Application Ref:	3/2026/0377			 Ribble Valley Borough Council www.ribblevalley.gov.uk
Date Inspected:	29/05/26	Site Notice:	12/06/26	
Officer:	AR			
DELEGATED ITEM FILE REPORT:				APPROVAL

Development Description:	Proposed single storey orangery style extension including alterations to hardstanding, patio area and removal of existing vegetation near boundary.
Site Address/Location:	Ravenswing House Church Lane Mellor BB2 7EY

Drawing Title:  
**PROPOSED ELEVATIONS**

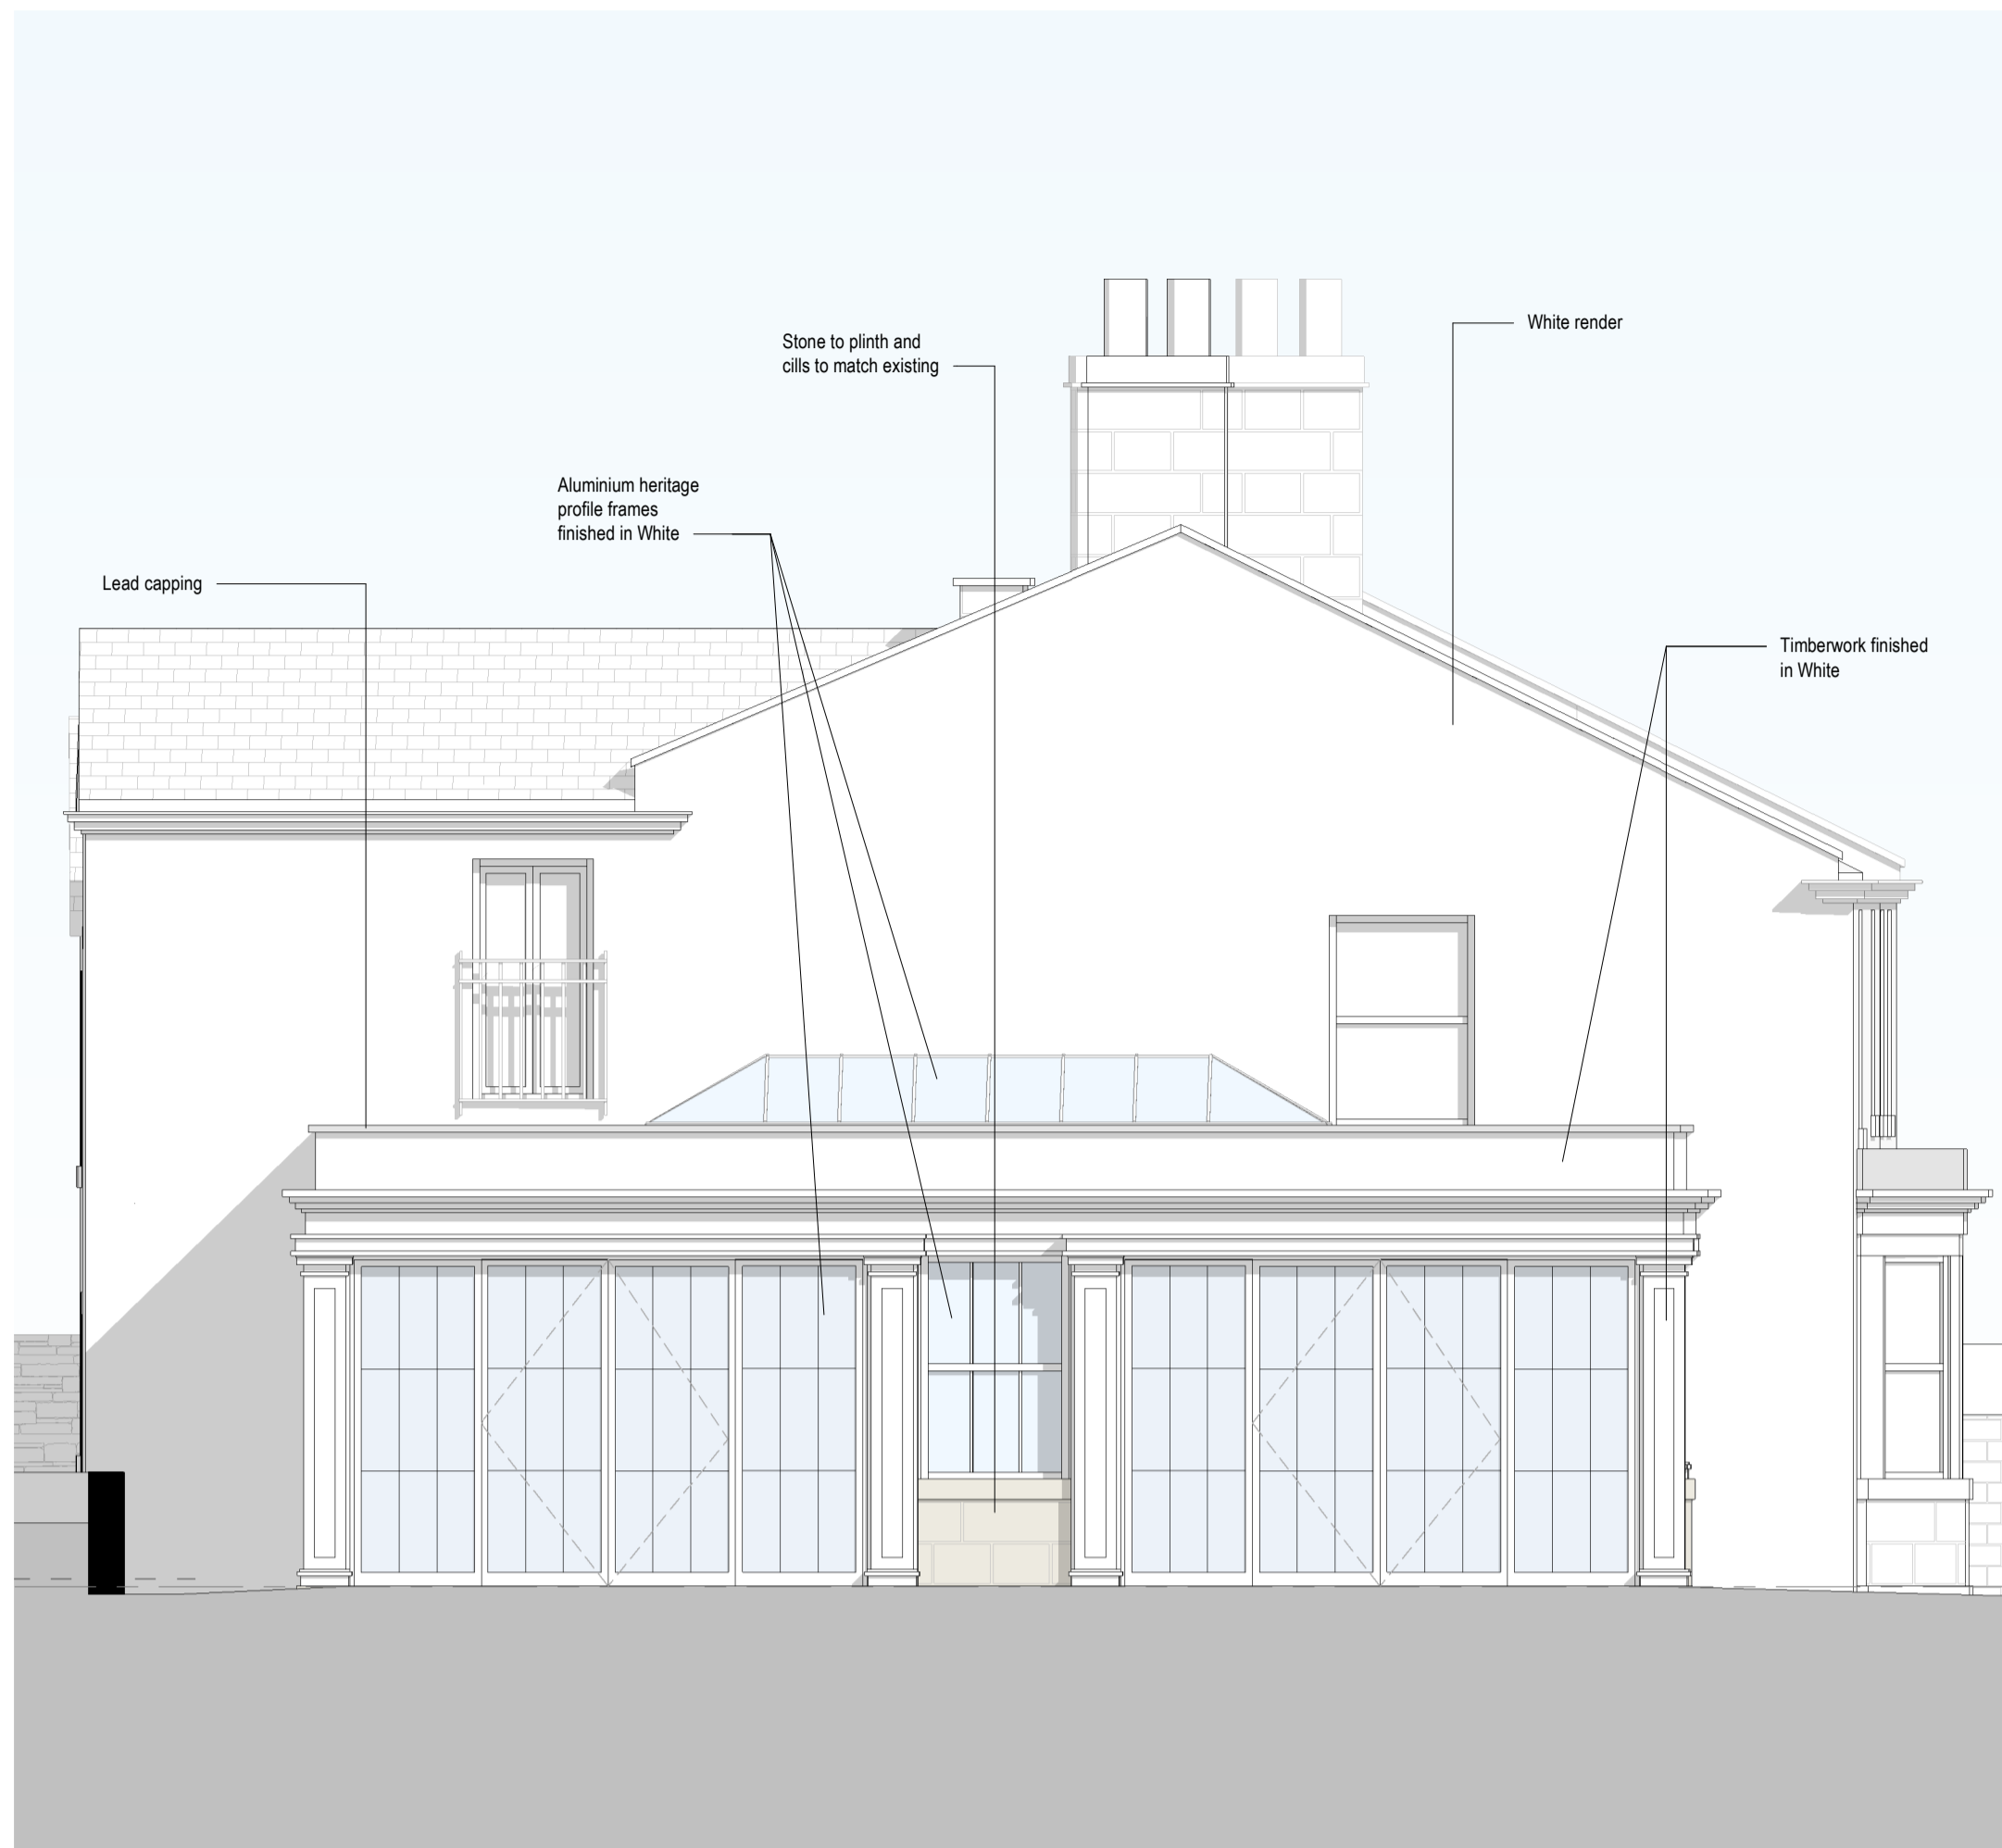
The proposed extension would have a total projection of 4.49m from the dwelling's west elevation, with a width of 9.78m, and would incorporate a flat roof form, which would measure 3.3m to the ridge and would feature a roof lantern with a maximum height of 3.8m.

With respect to materiality, the proposed extension would be finished in natural stone, with a grey flat roofing membrane and would feature white-painted aluminium-framed windows on its north, south and west elevations, all to be in keeping with the existing dwellinghouse.

The openings proposed to north, south and west elevations would provide views predominantly towards the private amenity space associated with the application property, and therefore, no new opportunities for direct overlooking or loss of privacy are anticipated in this respect.

The proposed extension will incorporate a flat roof design with a ridge height of 3.3 meters. Additionally, a roof lantern is proposed, increasing the extension's maximum height to 3.8 meters. This ensures the extension remains entirely subservient to the main property in terms of height. Occupying approximately two-thirds of the width of the property's western elevation, the extension's outward projection will be relatively modest at 4.4 meters, and it will not constitute an over dominant feature.

Drawing Title:  
**PROPOSED FLOOR PLANS 1 OF 2**

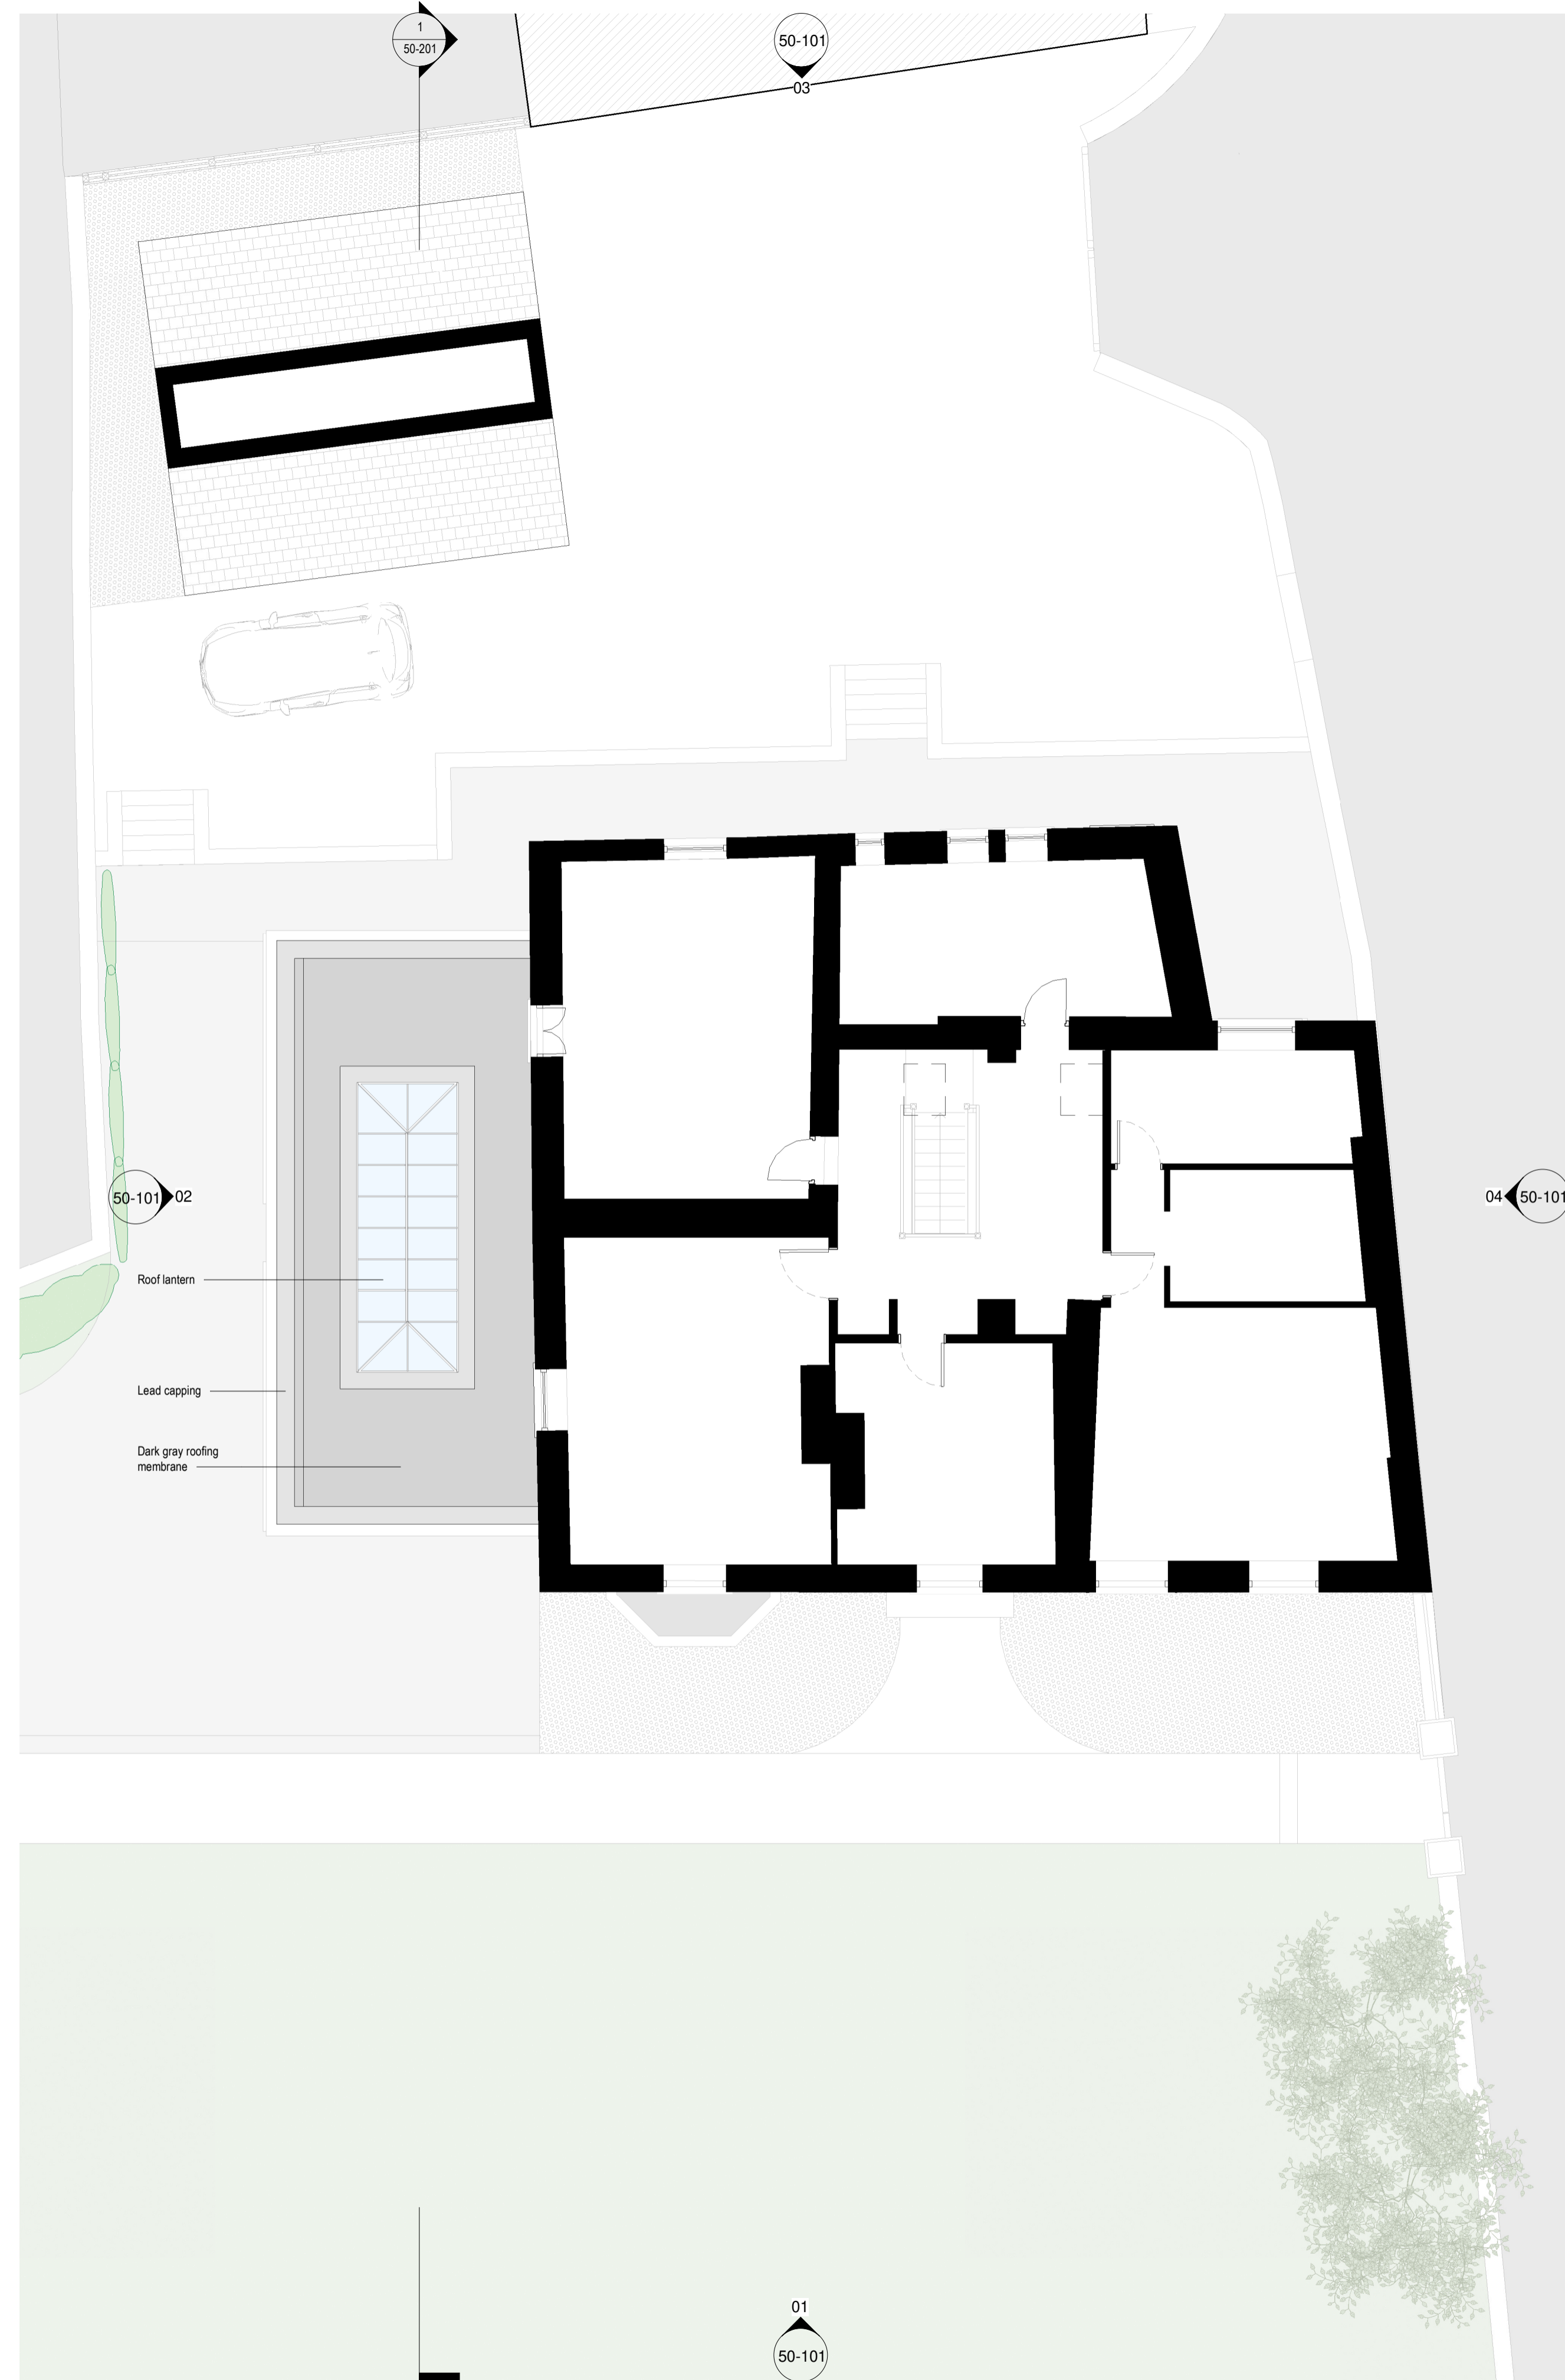
Furthermore, the extension to the patio, positioned at the rear of the dwelling, will be out of sight from the public realm and therefore raises no visual amenity concerns. In conjunction with this, the retaining wall along the northern elevation will be set back by approximately 2 meters to allow for the repositioning of the existing steps, ensuring their alignment with the western stone boundary wall and further minimizing any potential visual impact.
